Re: Sound Management Plan

Following on from my e-mails on Friday and Monday, please see below a summary of the Peer Reviewer (HMMH 3.7.19) recommendations in respect of your *Sound Management Plan*. The ones in **bold type** (under headings) appear to be the most important:

We have now received the attached Peer Review from our consultants HMMH and had a chance to digest their analysis and recommendations. HMMH were the City's consultants back in 2003-2005 when the location for the existing helipad was under review and we therefore engaged them to help review your submitted *Sound Management Plan* and associated documents.

Figure 1 – Sound Measurement Locations

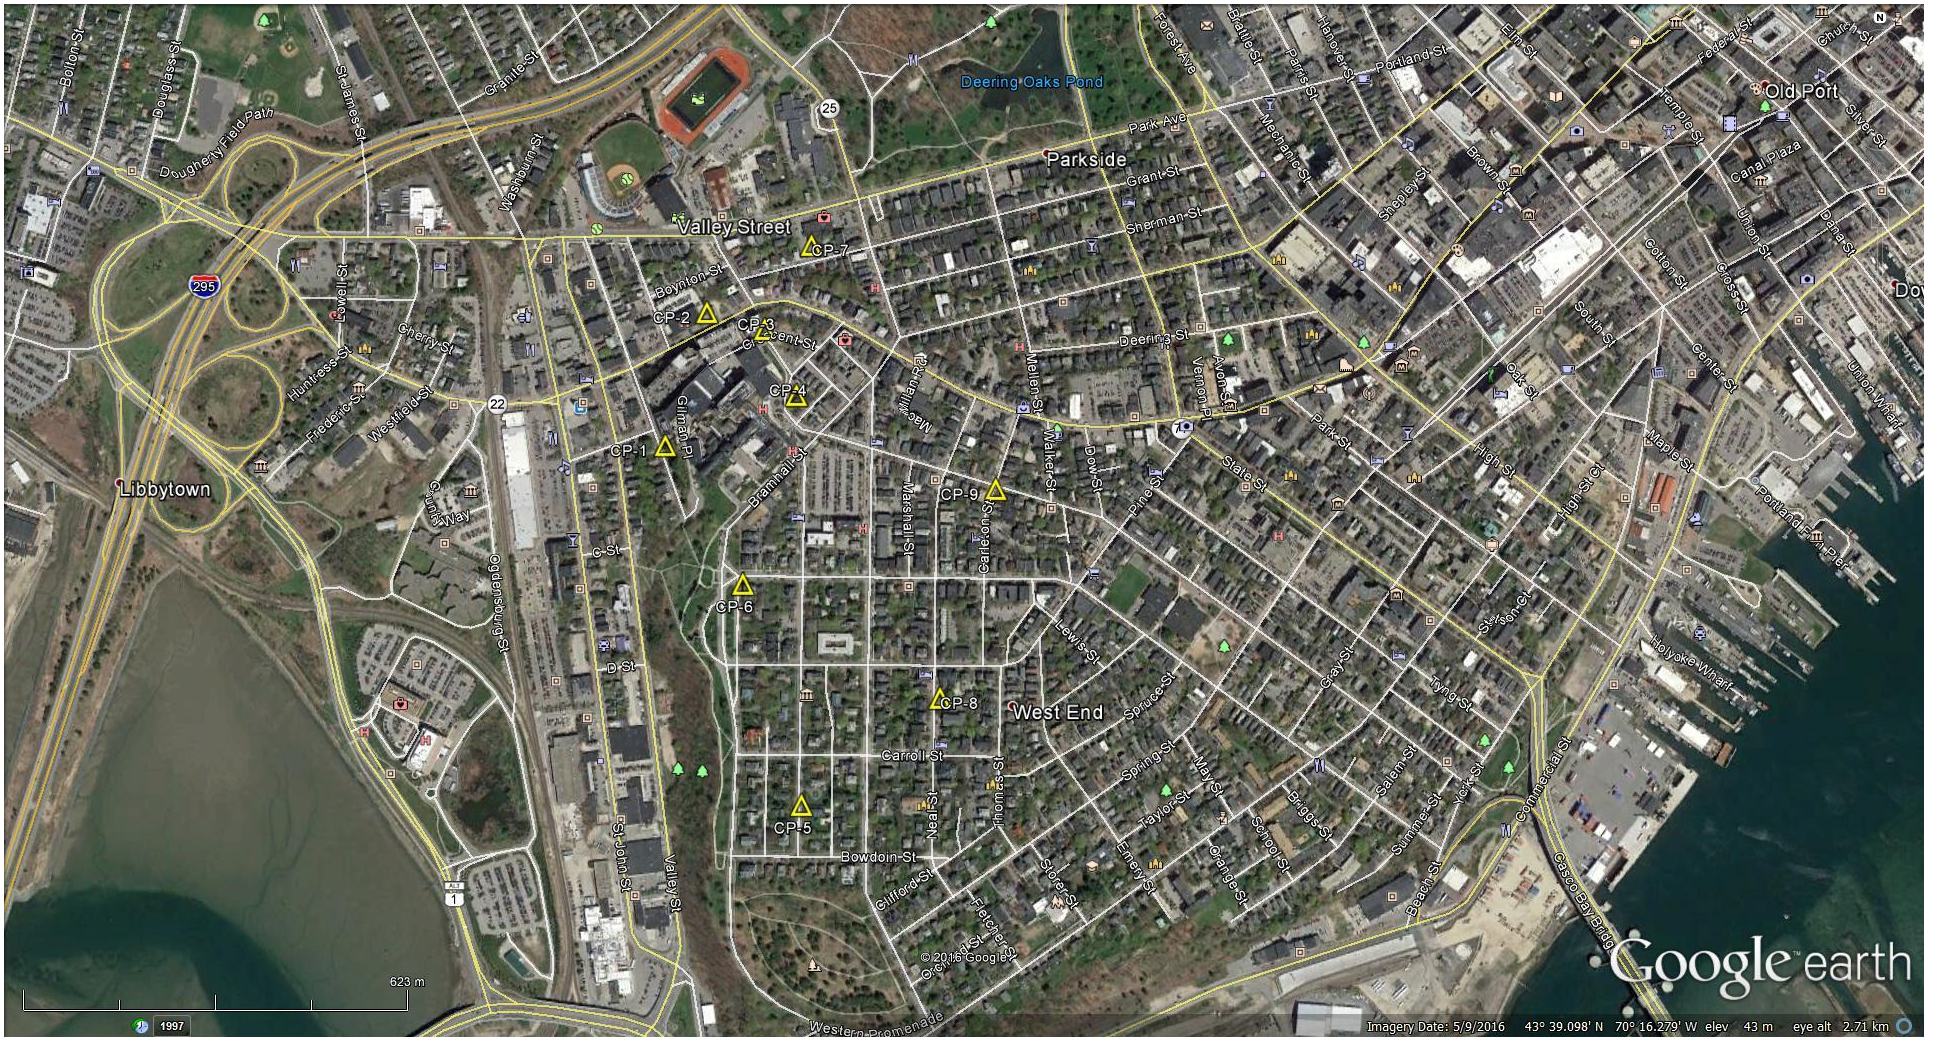
- Clarify location of sound devices relative to flight paths (5.1)
 - **Add in measurement location between CP-3 and CP-4 and collect data as for others (5.2)**

Thank you for the information re figure 3, and HMMH would like the coordinates or street addresses for each of the points on figures 1 and 2.

- a) Sound measurement locations shown in the Study's Figure 1
